Ribble Valley Borough Council
Council Offices
Church Walk,
Clitheroe
Lancashire
BB7 2RA

Phone: 0300 123 6780
Email: Kathryn.Walsh@lancashire.gov.uk
Your ref: 3/2024/1028
Our ref: 3/2024/1028/HDC/KW
Date: 13 March 2025

Location: Apple Tree Cottage 4 Orchard Cottages Branch Road Waddington
BB7 3HR
Proposal: Proposed single-storey side extension and internal alterations.
Grid Ref: 372959 443887

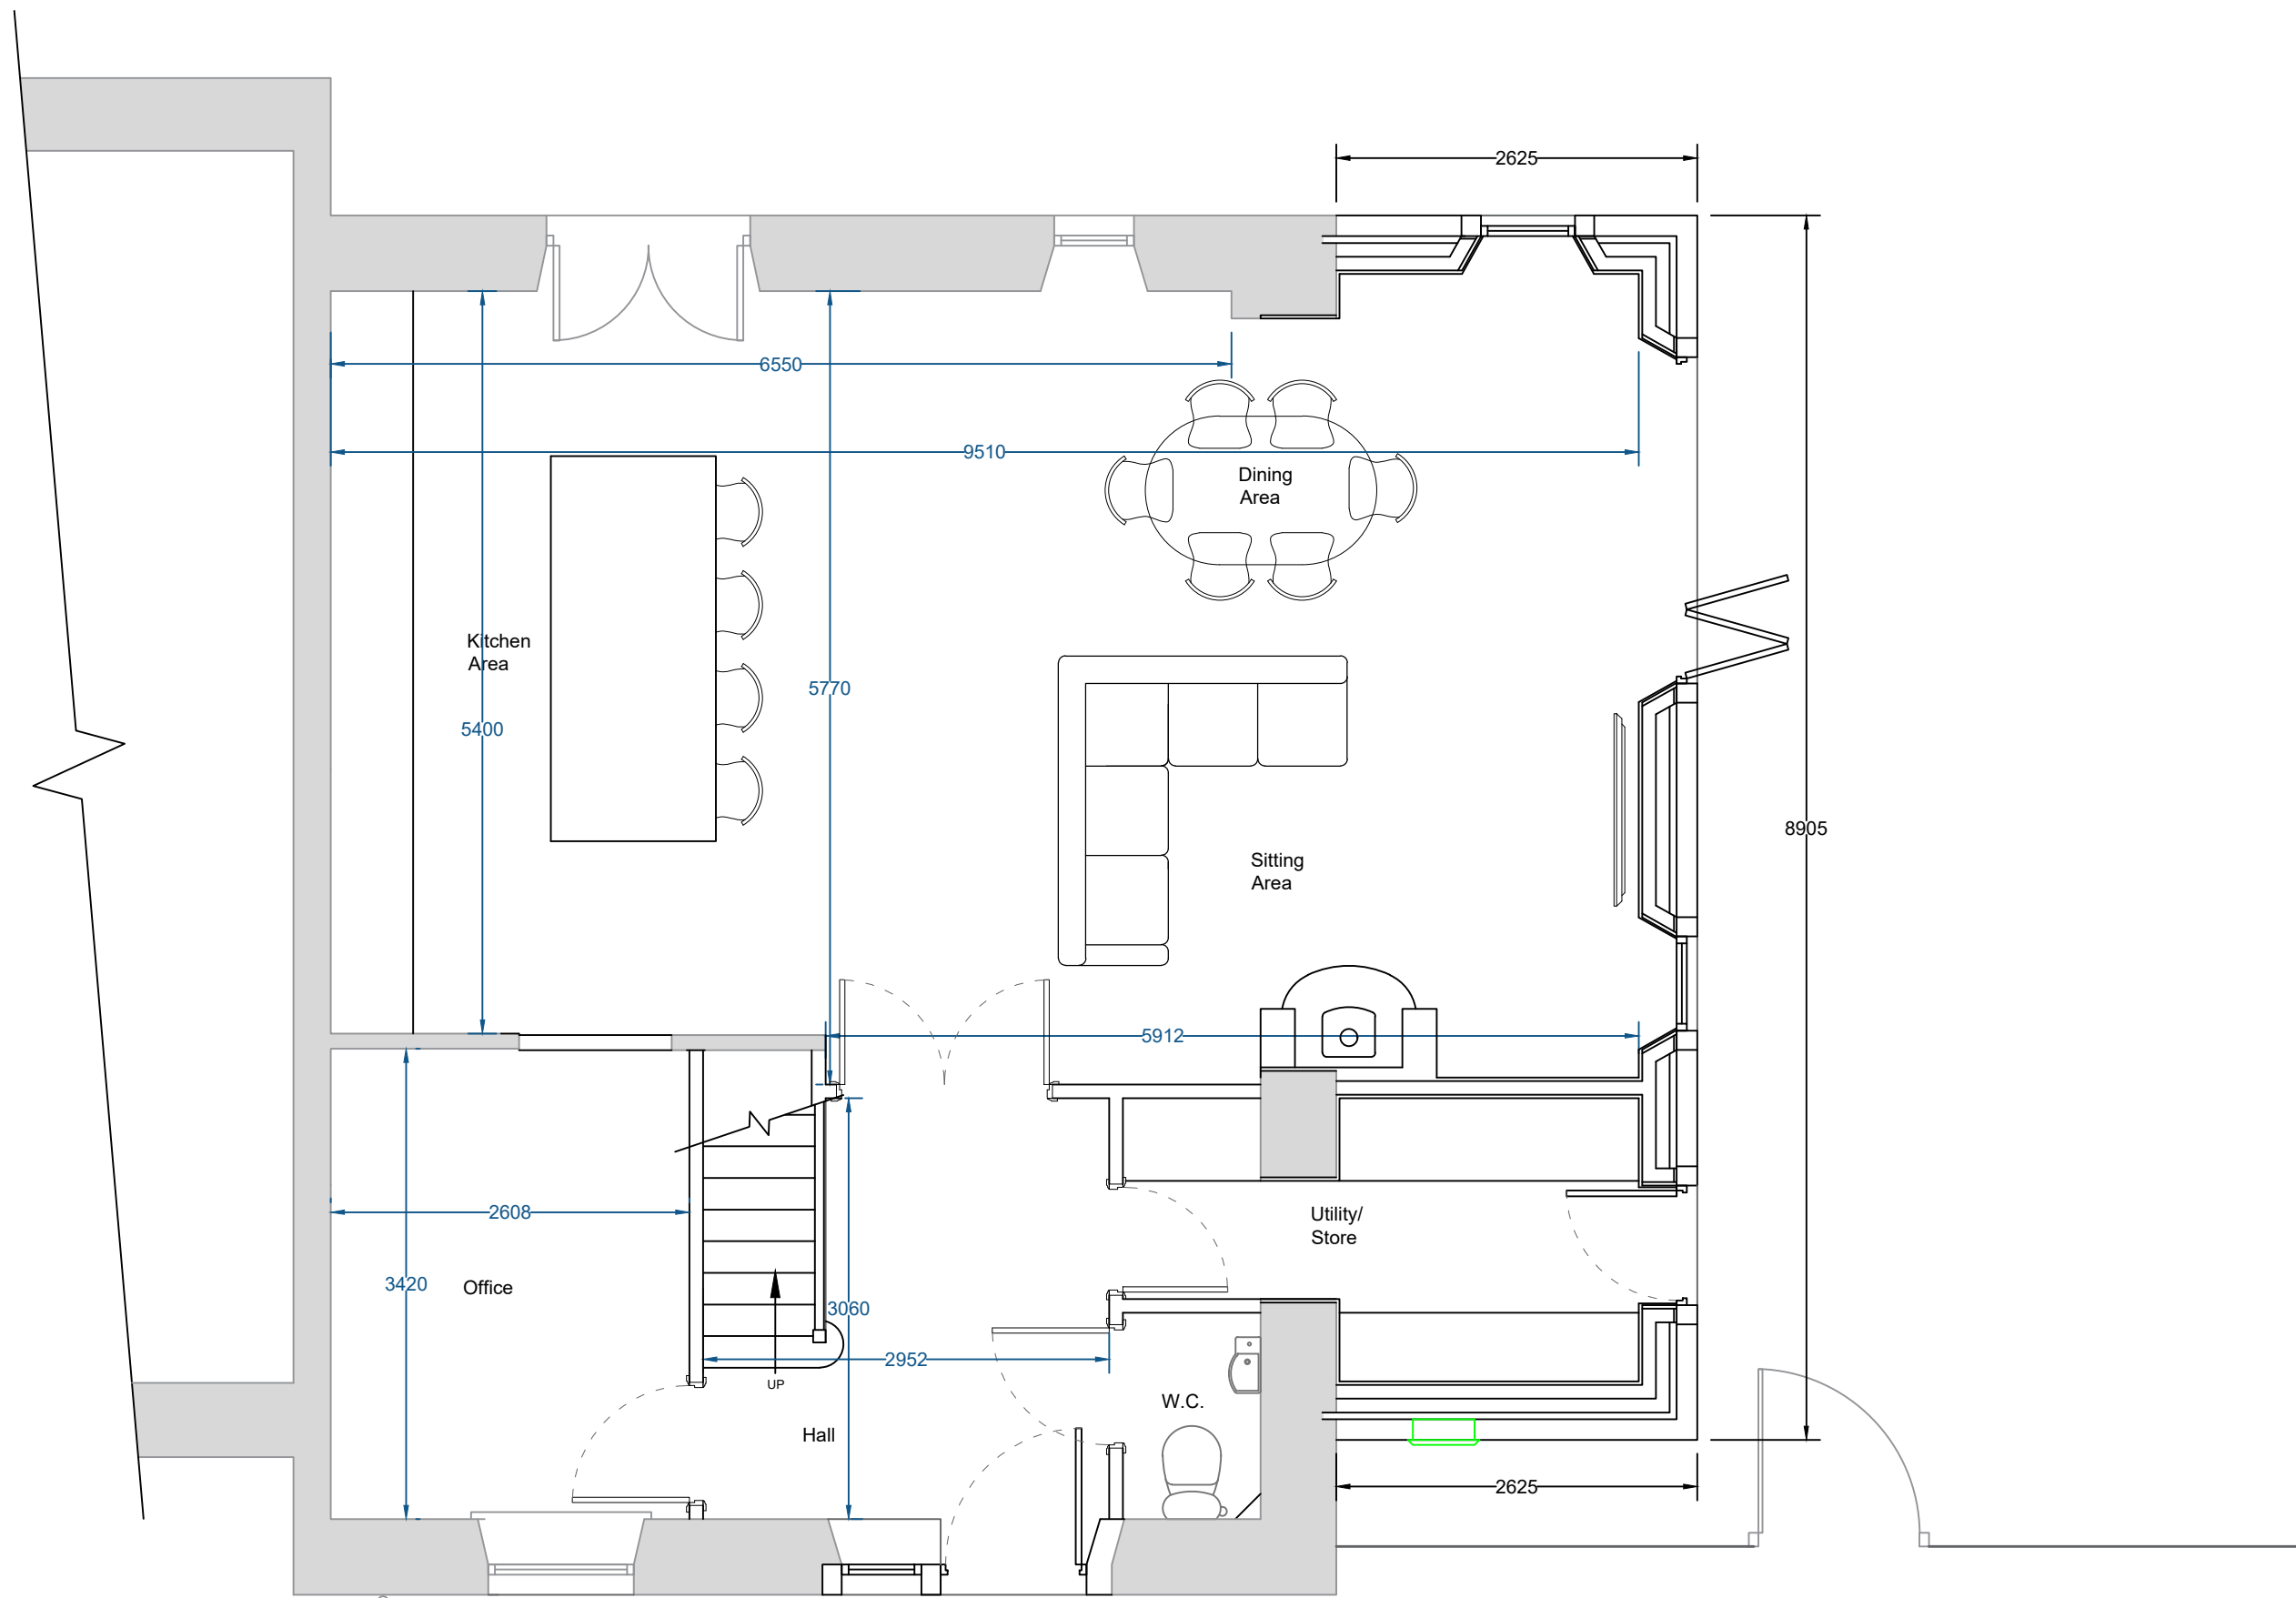
A 3-bedroom dwelling should have 2 off street parking spaces to comply with the LHAs parking standards as defined in the Joint Lancashire Structure Plan. These spaces should measure 2.4m x 5m where they are adjacent to a fence or similar obstruction an additional width of 0.6m should be provided. Where the driveway is shared pedestrian access an additional 0.8m should be provided.

The original permission for the cottages, as noted in the site plan under planning application 3/2013/0319, included parking and turning provisions outside of the private access road, which should continue due to the single-track nature of the private access road to the development. An extract from the previous permissions is shown below:

Therefore, it is expected that parking and turning provisions be provided adjacent to the dwelling, as such a proposed parking plan should be provided as part of this application.

In conclusion, compliance with parking standards under the Joint Lancashire Structure Plan remains a key requirement. It is essential that two off-street parking spaces, meeting the specified dimensions and allowances, are provided for the 3-bedroom dwelling. The continuation of parking and turning provisions, as outlined in the original planning permissions, is necessary due to the single-track nature of the access road. A proposed parking plan should therefore accompany this application to ensure adherence to these standards.
